Job No: 2023-5274
File Ref: N03-CC-Transport Addendum F2 (241127)
Date: November 2024
Job Title: 148-154 High Street, Uxbridge

Subject: Transport Assessment Addendum: GLA / LBH Response

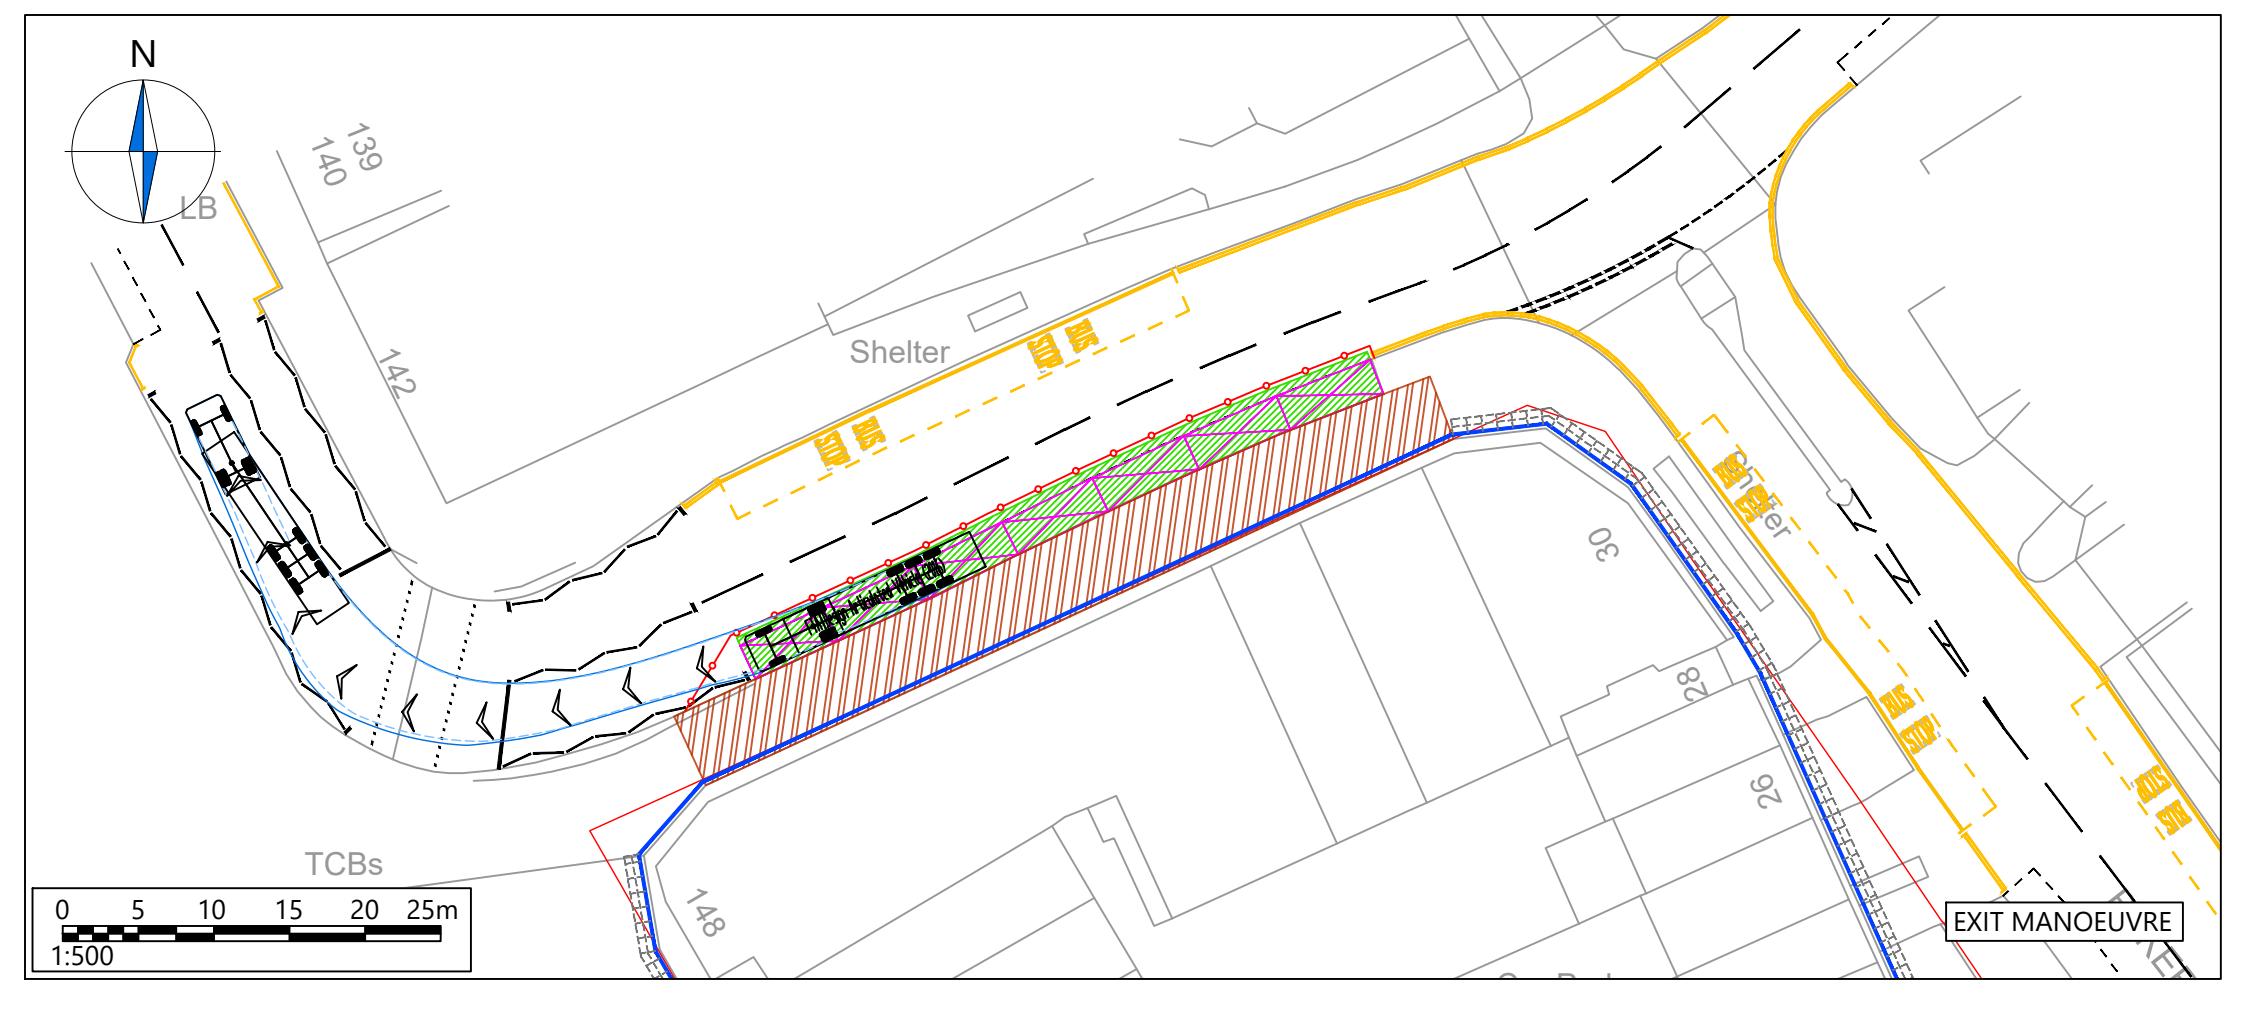
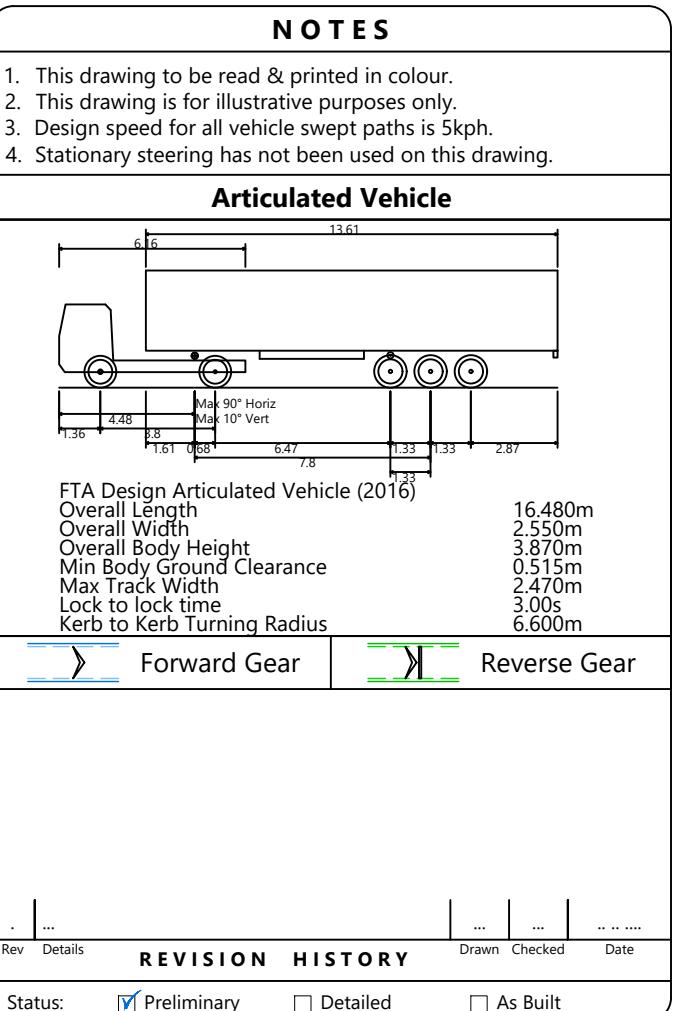
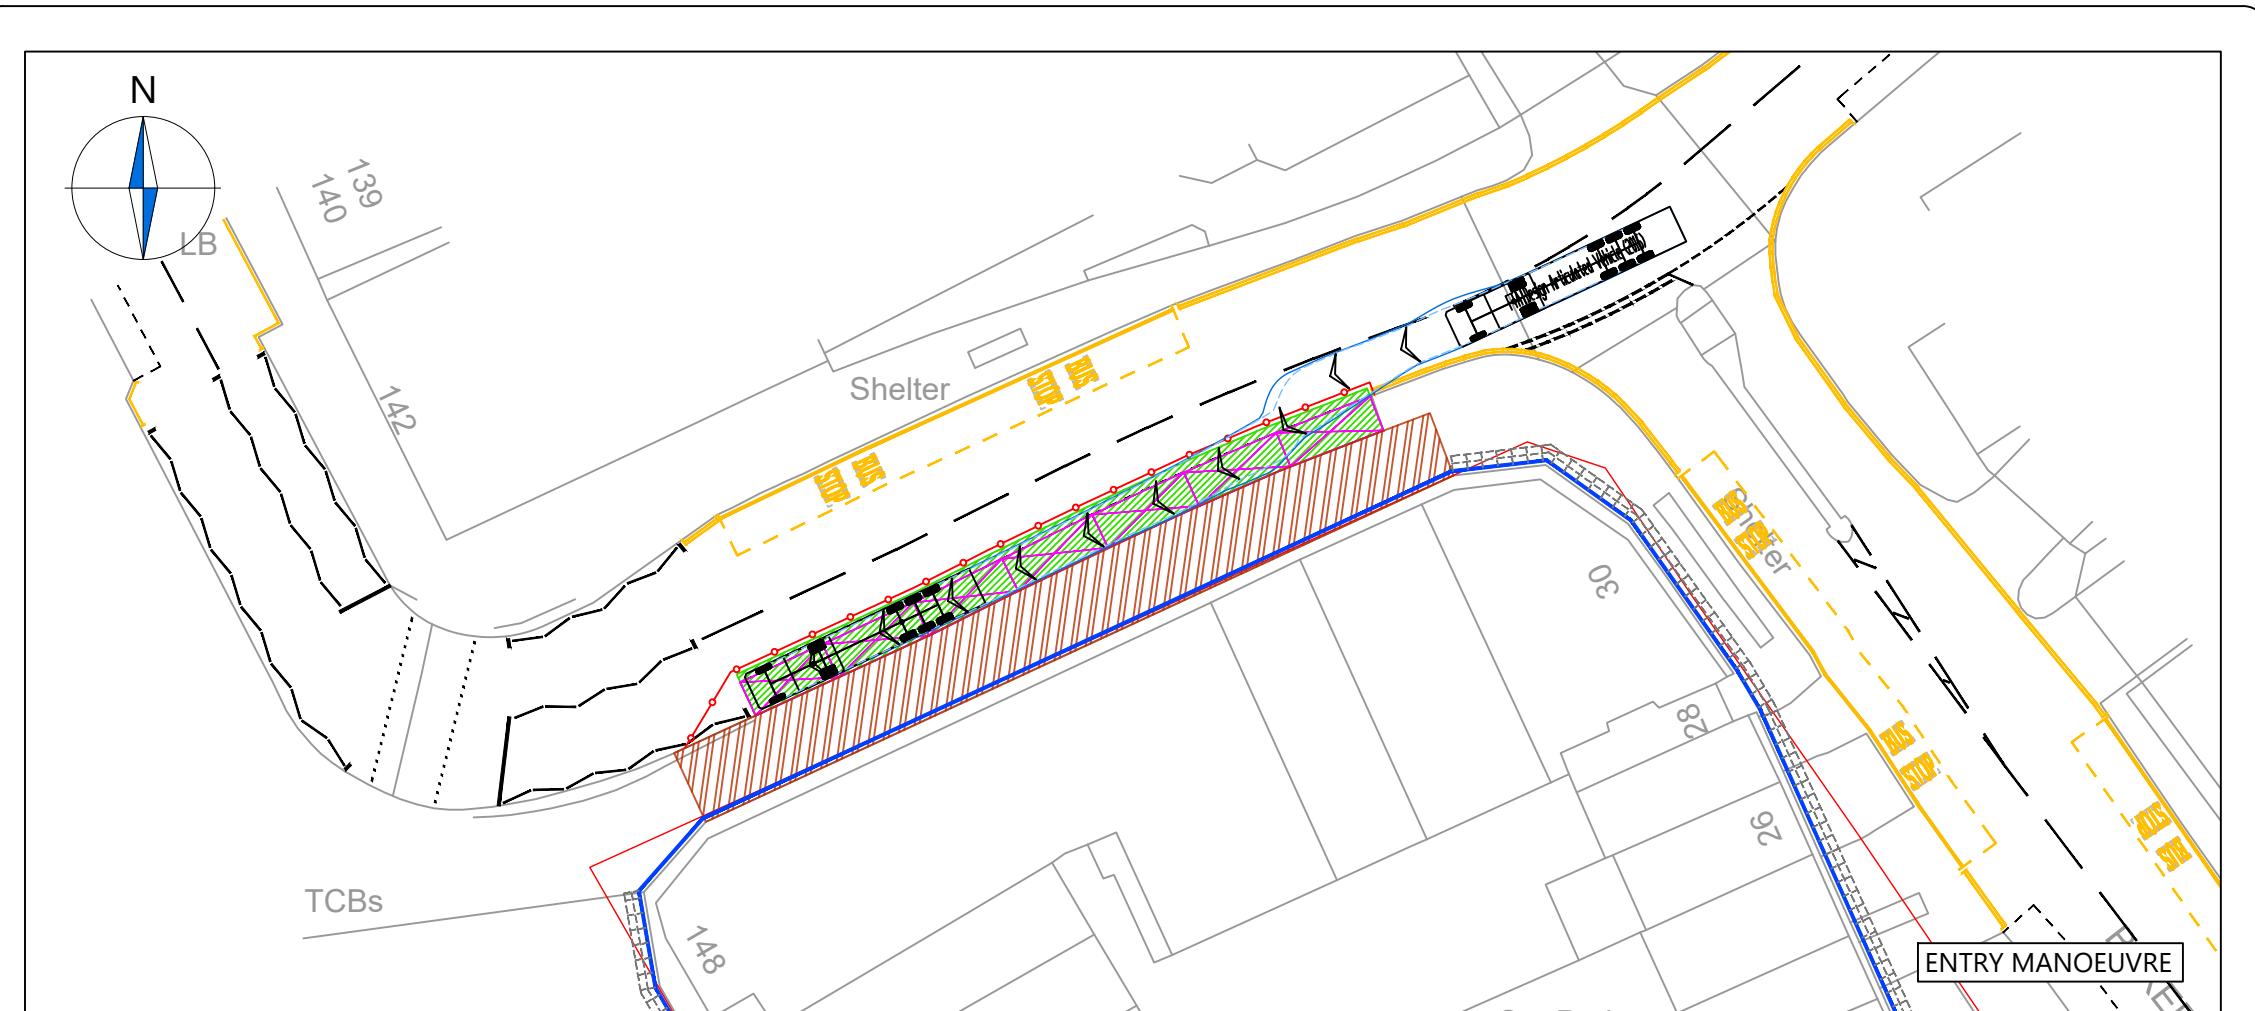
GLA Comment: *58. Potential streetscape enhancements have been identified on Belmont Road. Whilst the principle is welcomed, it is not clear how these will be integrated with the proposed loading bay and retained parking spaces. Further improvements to Belmont Road should be introduced to improve the pedestrian experience and road safety in the town centre.*

12. The potential improvements to Belmont Road have been agreed with Hillingdon. The proposals seek to reorganise the existing parking spaces across the site frontage to introduce a loading bay to serve the development, reducing the demand for space on Bakers Road. The proposals require the relocation of 2no. accessible bays and 1no. motorcycle bay where space exists on Belmont Road, at the expense of standard parking spaces. This is complemented by a widening of the footway on Belmont Road as the proposed building façade is pulled away from the site boundary with high quality landscaping and short stay cycle parking incorporated within land controlled by the Applicant.

13. The alterations can be seen in the Proposed Highway Arrangement plan that was attached to the Transport Assessment and included at **Appendix C**.
14. On the basis of the above, the proposed development will deliver notable improvements to Belmont Road, including improving the streetscape and pedestrian environment.
